| Application Ref: | 3/2021/0172 |  Ribble Valley Borough Council www.ribblevalley.gov.uk |
| DELEGATED ITEM FILE REPORT: | | APPROVAL |

| Development Description: | Change of use of first floor from manager's flat to offices. |
| Site Address/Location: | Kings Arms 144 Bawdlands Clitheroe BB7 2LA |

PROPOSED FIRST FLOOR PLAN
SCALE 1:100

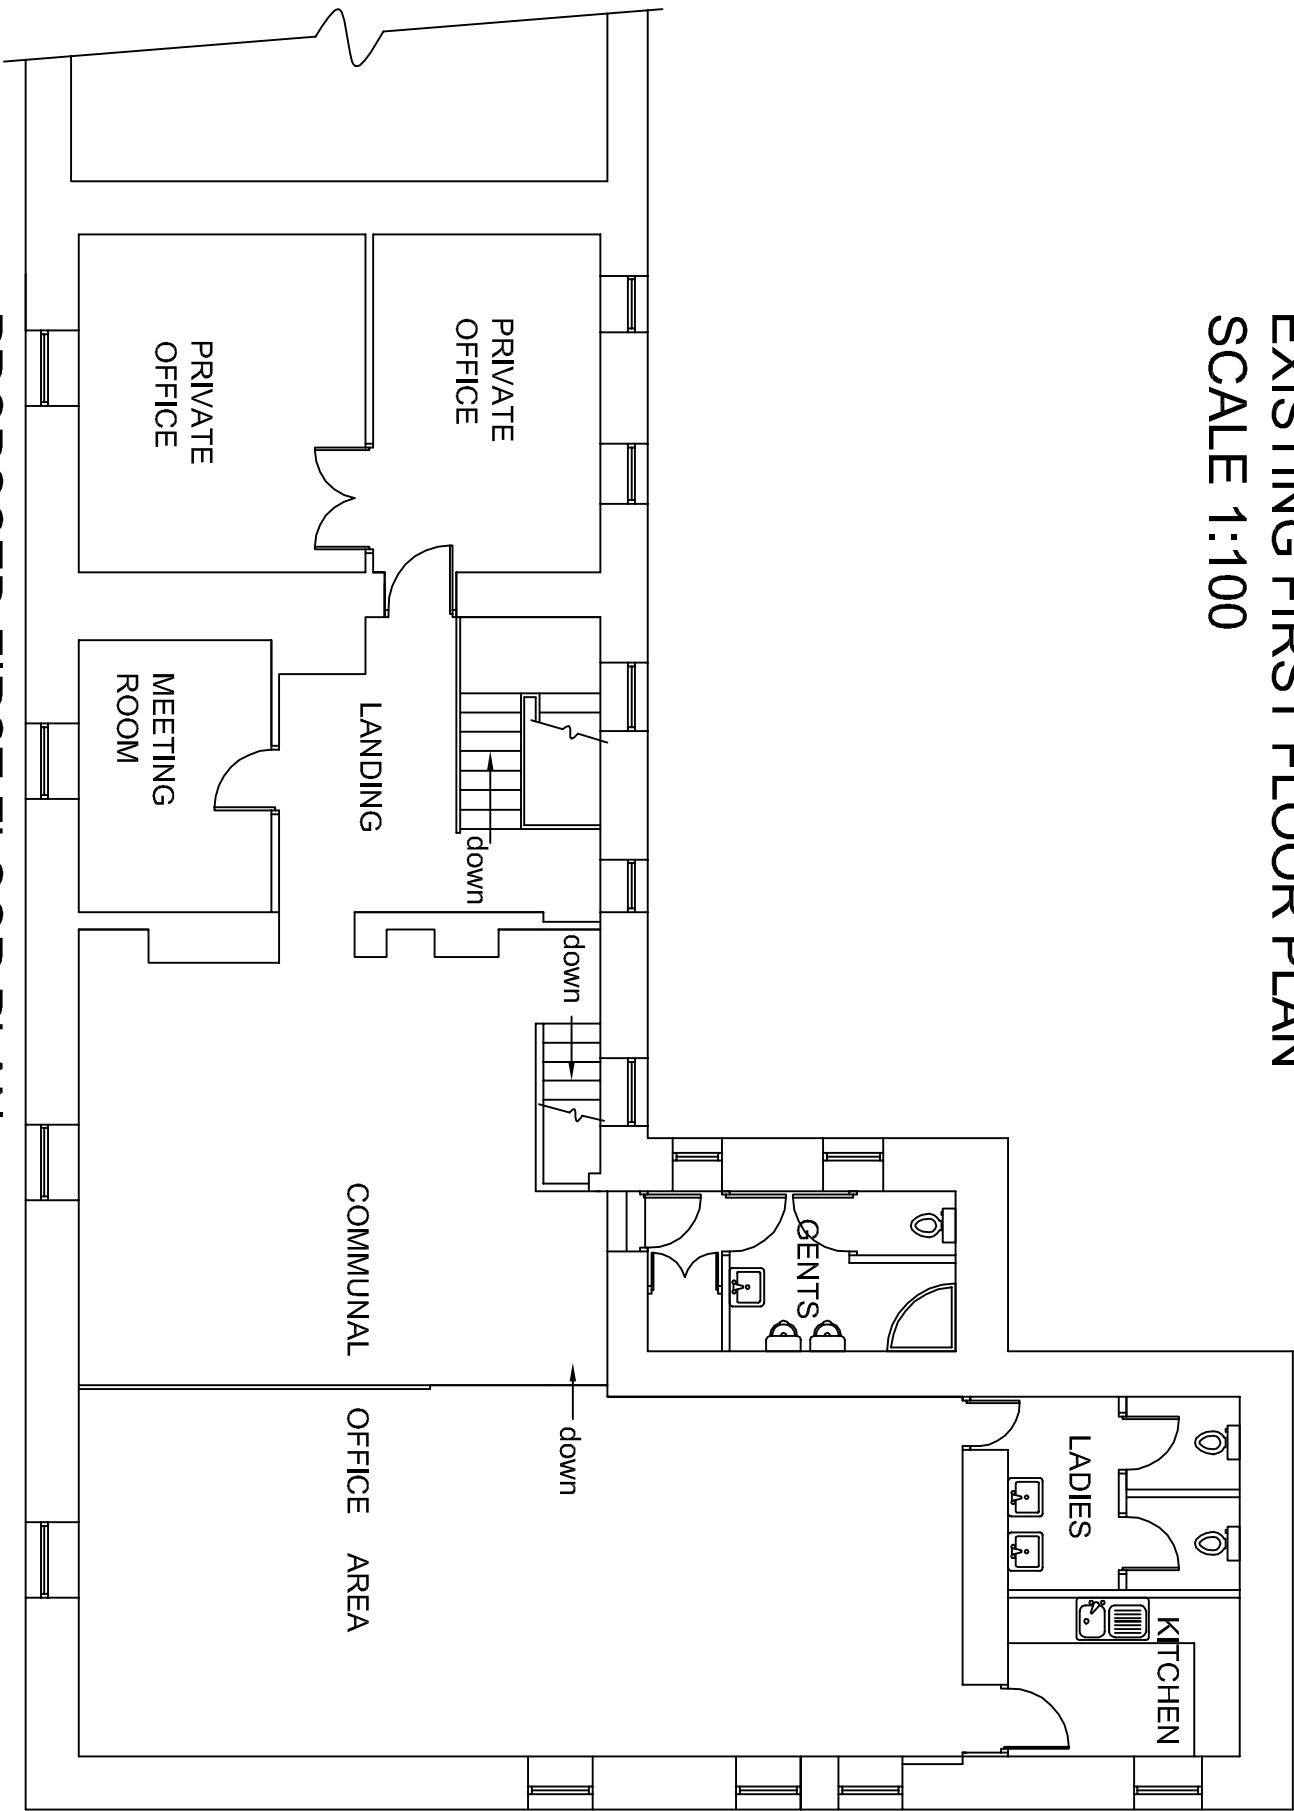
The submitted details propose no external alterations with internal alterations being limited to that of changes to the internal configuration of the existing bathrooms and the use of all rooms to that of office use including two private offices, one meeting room and a communal office area.

However, taking account of the proposed internal configuration of the proposed Class E use it would appear that the garden area will be overlooked by a private office which is currently a bedroom. In this respect I consider the amount of potential overlooking of the private garden area of the neighbouring property resultant from the proposal to be commensurate with that of the current residential use when the bedroom is occupied. Further to this matter the applicant has stated that the offices will only be utilised Monday to Friday 08:00 – 18:00, Saturdays 08:00 – 18:00 and Sundays/Bank Holidays 10:00 – 15:00. This will result in the office only being occupied during the day and to a lesser extent than if the room were utilised as a bedroom which could be occupied 24 hours a day.

In respect of the above matters I therefore do not consider that the proposal will result in any significant undue impact upon privacy above that which would already be experienced should the premises be occupied by residential occupiers.
